**WELWYN HATFIELD BOROUGH COUNCIL – DEVELOPMENT MANAGEMENT
DELEGATED REPORT**

APPLICATION No:	N6/2013/1886/FP
APPLICATION Site:	5 Orchard Close, Cuffley

This application seeks planning permission for the following works:

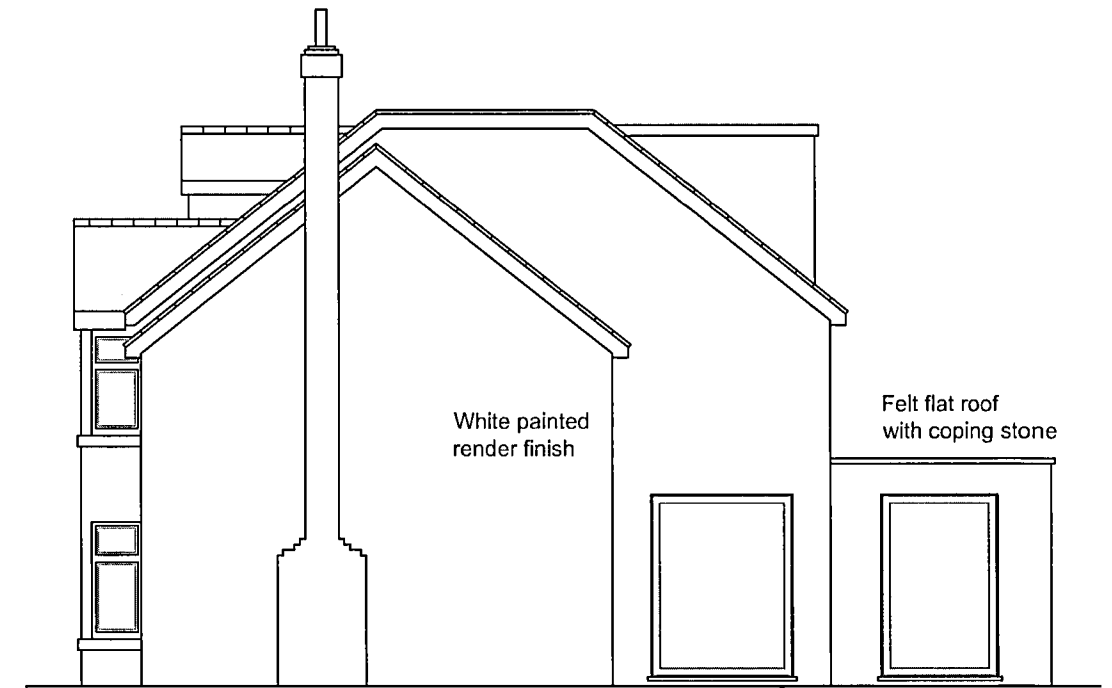
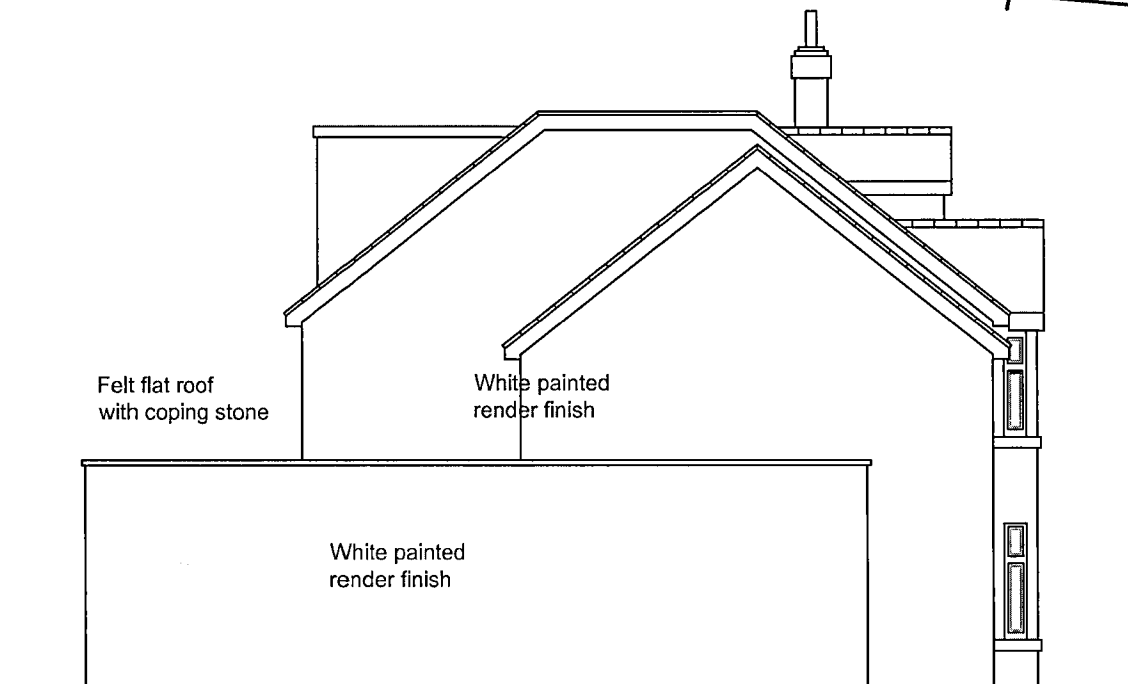
The proposed extensions to the host dwelling would make a marked difference to its appearance in the streetscene. The existing dwelling is simple in its design and character and the proposal seeks to create a much grander dwelling. The two storey extensions at either side would both measure nearly 3 metres wide and would increase the overall width of the host dwelling from approximately 9.5 metres to over 15 metres wide at first floor level. The proposal involves the insertion of a pitched roof dormer in the centre of the front roof slope and roof lights at either side of the roof as well as the creation of double height bay windows with pitched roof / gable end details above. It also involves the relocation of the front door to the centre of the front elevation, with pillar details to either side.

With regards to changes to the rear of the host dwelling, these would also be substantial. The two storey rear extension would extend out from the rear of the original dwelling by nearly 3 metres and the roof height would match that of the original roof. The two flat-roof dormers to the rear would further increase the bulk of the dwelling as viewed from the sides and concern has been raised that the rear dormers are out of proportion with the host dwelling. The dormers comply with the guidance set out in the supplementary design guidance insofar as they are contained within the roof slope, they are subservient to the roof of the property and the fenestration matches fenestration at the rest of the property. Furthermore they do not extend above the ridge height of the existing dwelling and the dormer cheeks are over a metre away from the flank walls. On balance although the proposed extensions to the original dwelling are large in size, because the main bulk is located to the rear, where it would not impact on the streetscene or the character of the host dwelling as viewed from the front, it is considered that they are acceptable.

There is some discrepancy about the boundary line between the host dwelling and number 4, however this is not a material planning consideration. The plans illustrate that the two storey side extension would extend out from the side of the original house by 2.8 metres and it would be 0.4 metres lower than the main roof of the dwelling. The two storey rear element would extend out from the rear of the dwelling by 3 metres and, by reason of the crown roof design and the front and rear dormers in the roof slopes, the mass of building as viewed from number 4 would be greatly increased. The effect is made worse by the difference in ground levels, as highlighted by the occupiers of this property.

The occupiers of this property have raised concerns that there would be overlooking to their property as a result of the extensions, particularly the bay windows at the front. In general the extensions have been designed to avoid any overlooking to number 6. The only windows facing towards number 6 would be the side windows in the bay windows and there would be no other windows on the side elevation of the host dwelling (which a planning condition can ensure remains the case in the future). Any overlooking from the bay windows would be towards the front, 'public' side of the neighbouring property and it would be at an angle. On this basis it is not considered that the impact would be so great as to warrant a refusal of the application on this basis.

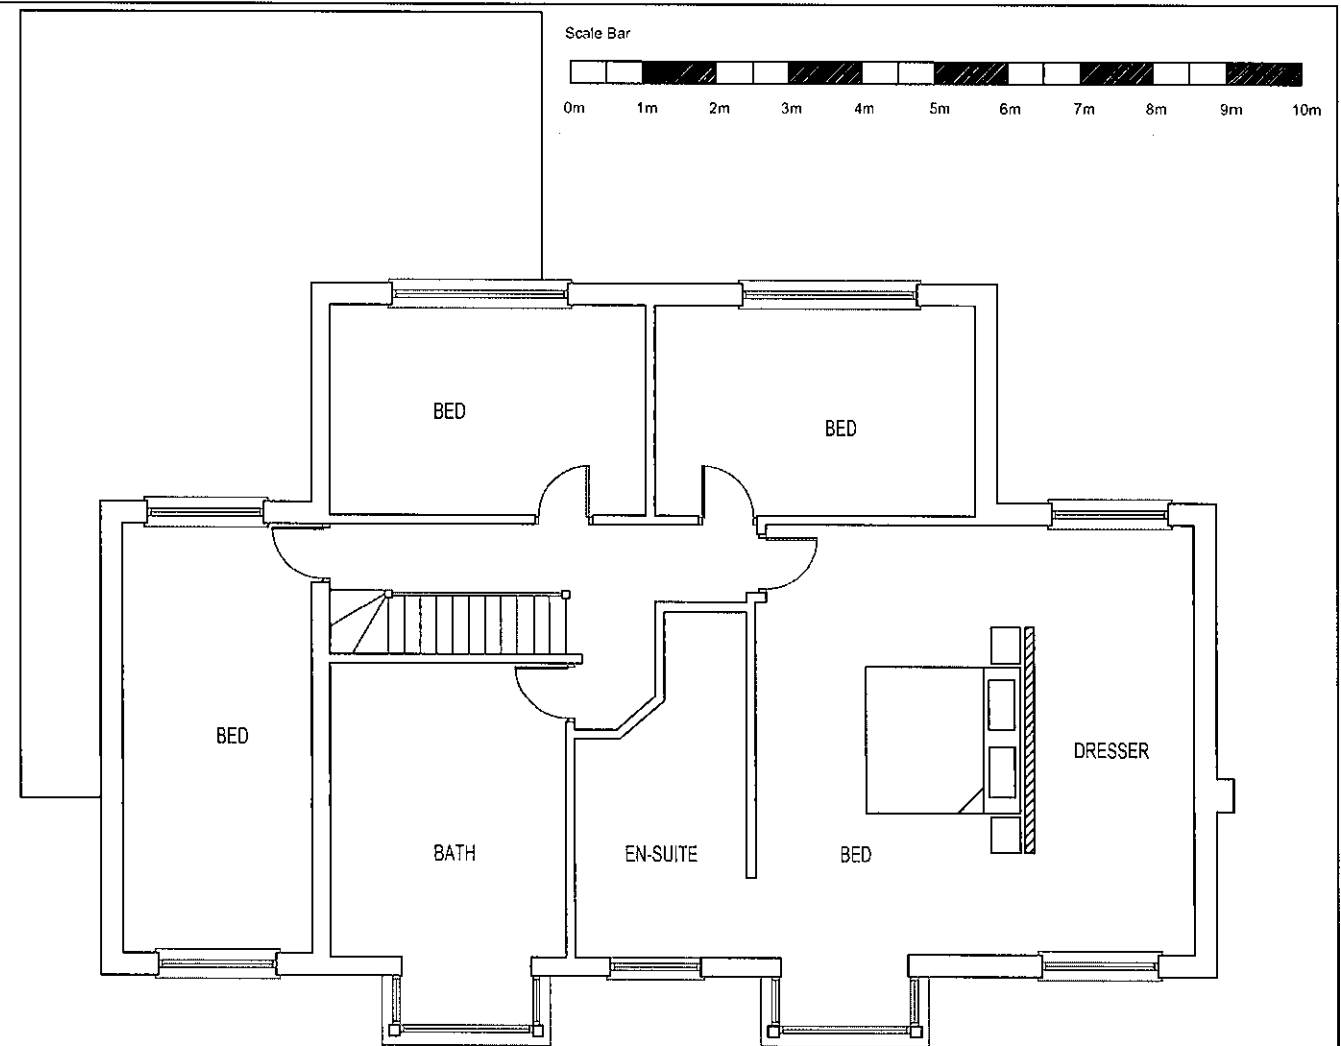
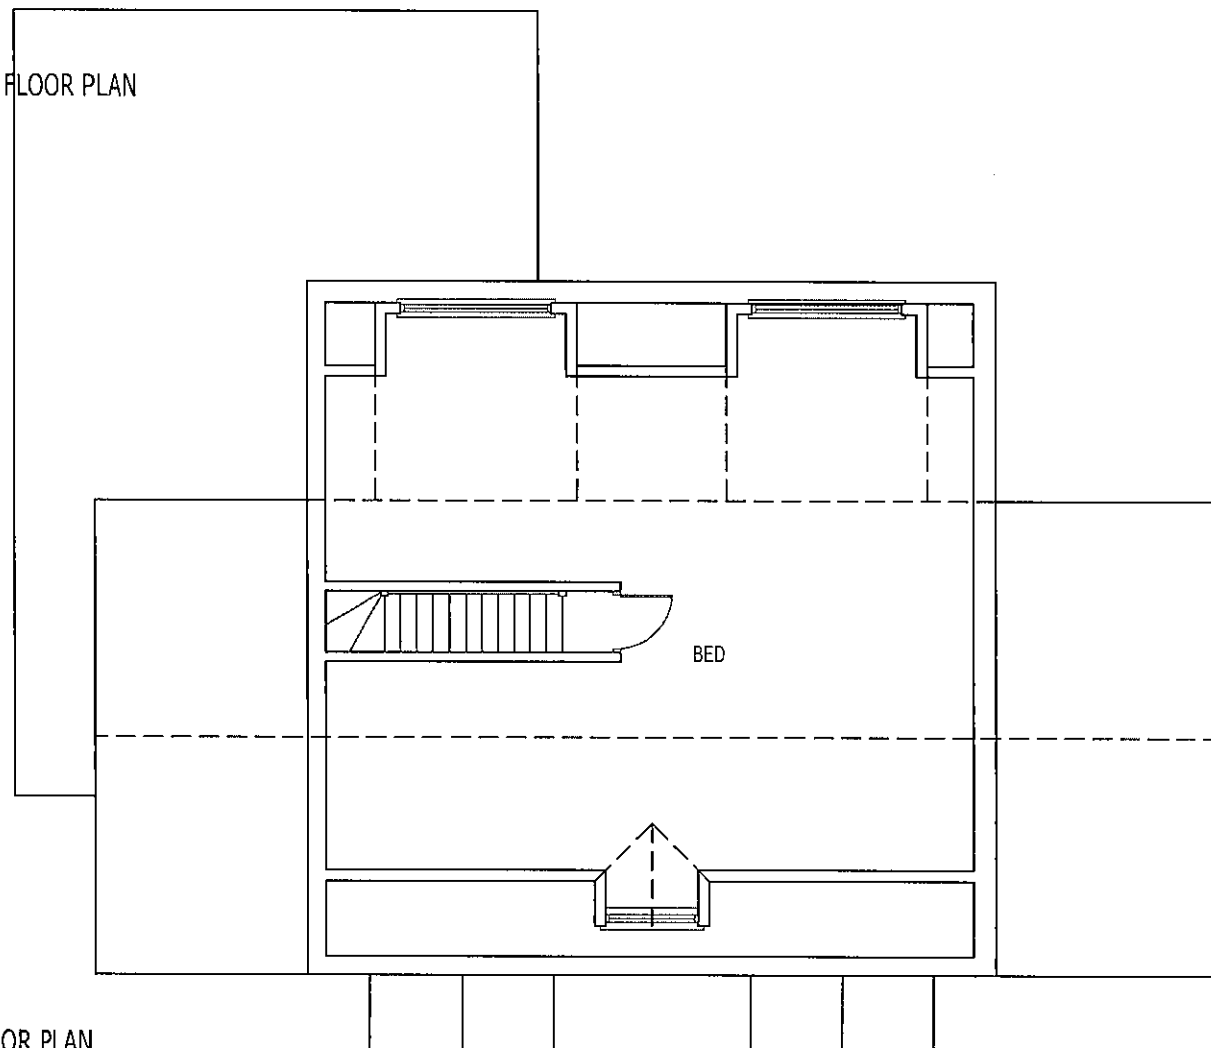
Concerns have been raised about inadequate parking provision at the site. The proposal involves the loss of a garage and an increase in size of the dwelling, which could lead to a need for more cars. The original dwelling had 4 bedrooms and the proposal would create 1 additional bedroom in the dwelling, although there may be

The submitted plans show a driveway to the front of the dwelling that would measure between 4 and 11 metres wide and at least 8 metres long. It is considered that 3 cars could be accommodated within this space in tandem whilst still allowing some degree of vegetation to be retained along the application site edges.

ADDRESS : 5 ORCHARD CLOSE, EN6 4QD			
PROJECT TITLE : EXTENSIONS AND LOFT			
DRAWING TITLE : SITE SECTIONS			
drawn	MIDAS PLANNING	scale	As shown @ A3
date	OCT 2013	dwg no.	378/06b

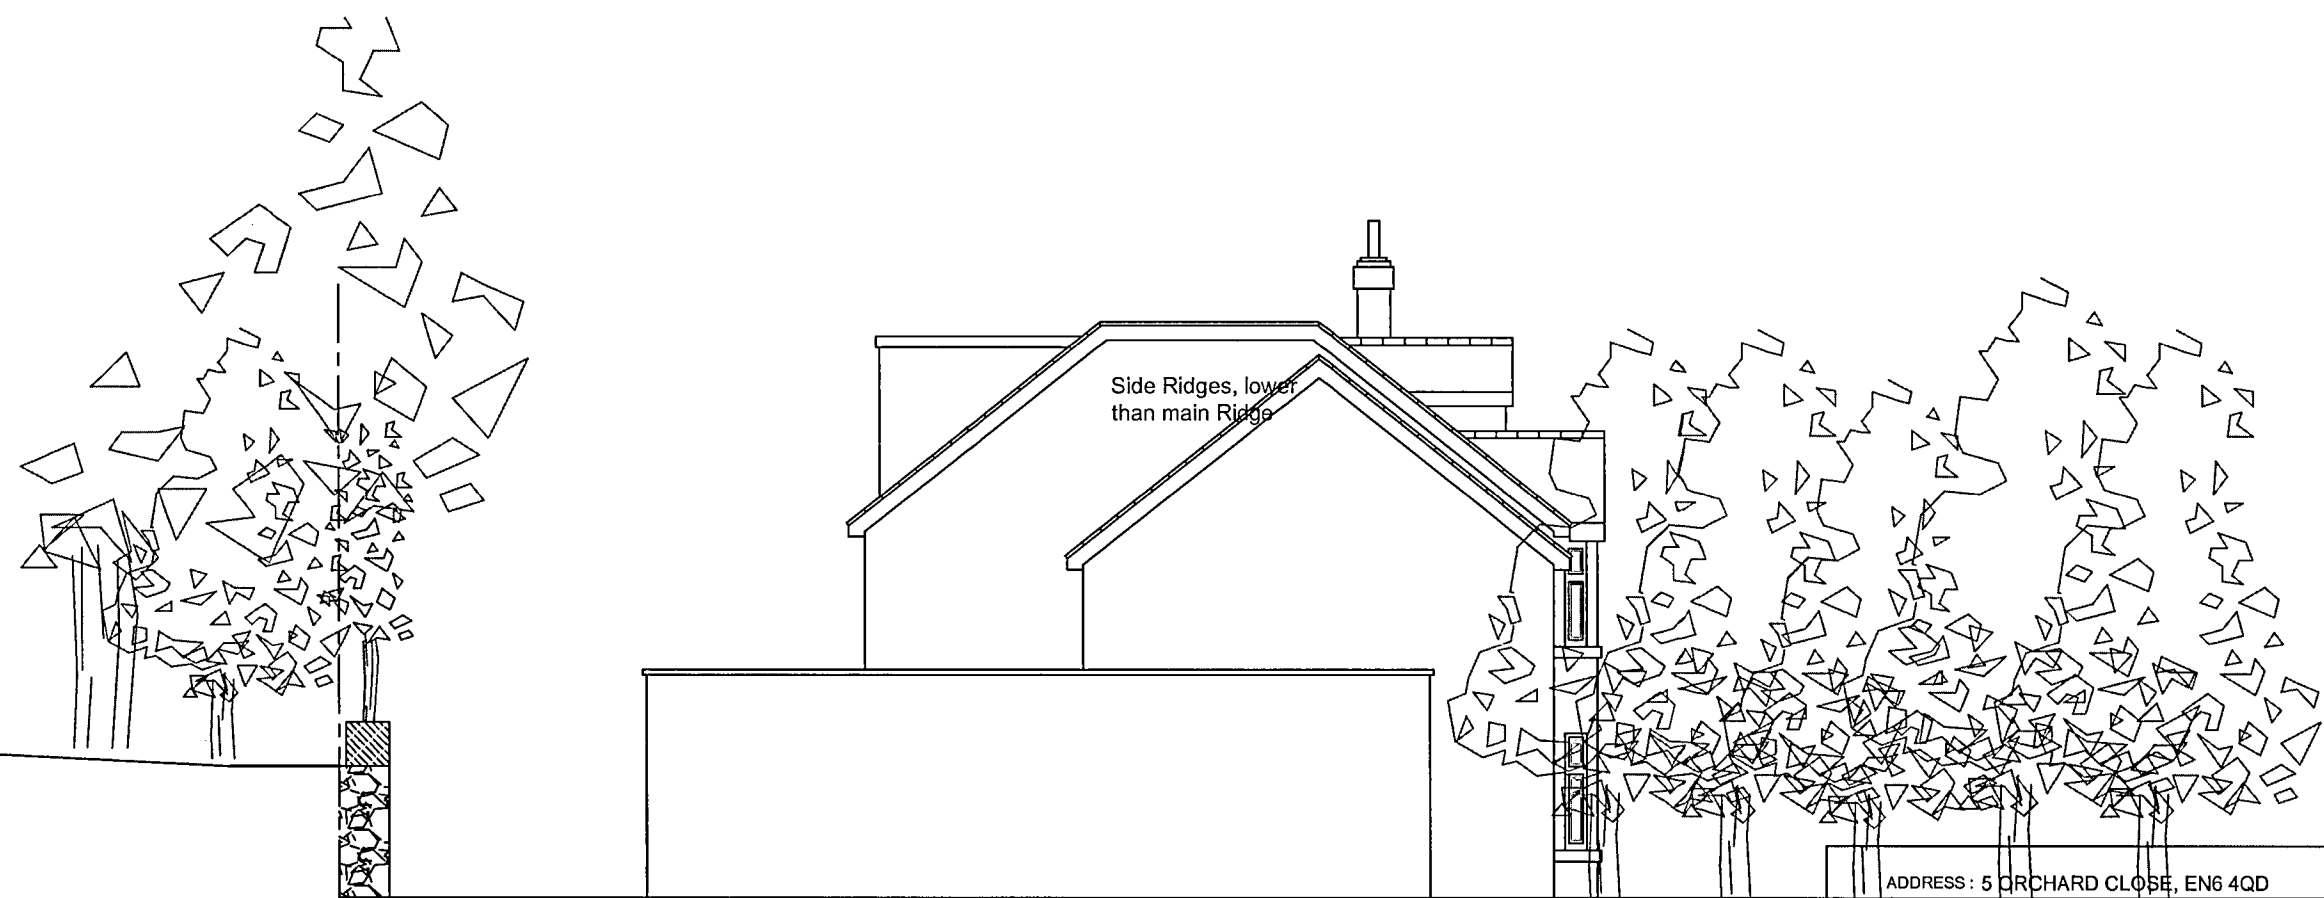
This property is located to the rear (south) of the application site. The two gardens are back to back, although the garden for number 36 is much larger and the two properties are currently separated by at least 30 metres.

The occupiers of number 36 have raised concerns that the extensions will directly overlook their living room / balcony, due to the difference in ground levels.

The separation distance of 23 metres is considered to be sufficient so that overlooking would not pose a significant problem, especially because of the angle at which the properties are placed in relation to each other, whereby the windows would not directly face each other. Furthermore, the planting of conifers along the boundary, referred to above, would help screen the application site from this property.
